OFFICIAL NOTIFICATION OF DECISION

Project# PR-2019-003222
Application#
SD-2023-00102 – PRELIMINARY/FINAL PLAT

For all or a portion of **TRACT B-4-A-1** zoned **MX-M**, located at **10000 COORS BLVD BYPASS RD NW between COORS BLVD BYPASS NW and SEVEN BAR LOOP RD NW** containing approximately **11.6524** acre(s). **(B-13)**

Easement No. 13 Detail

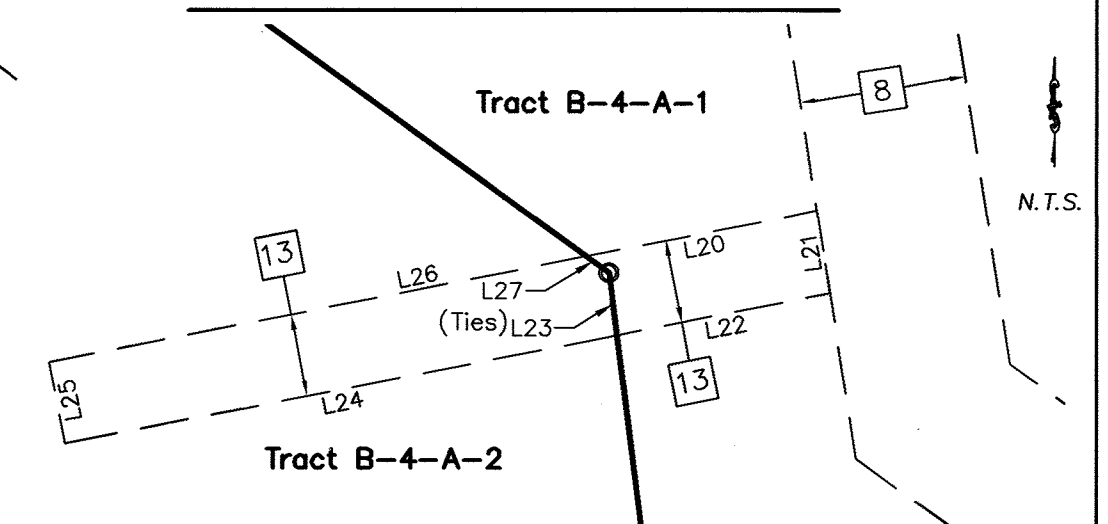
- a. The proposed sanitary sewer (Easement #13) recording information must be indicated on the Plat.
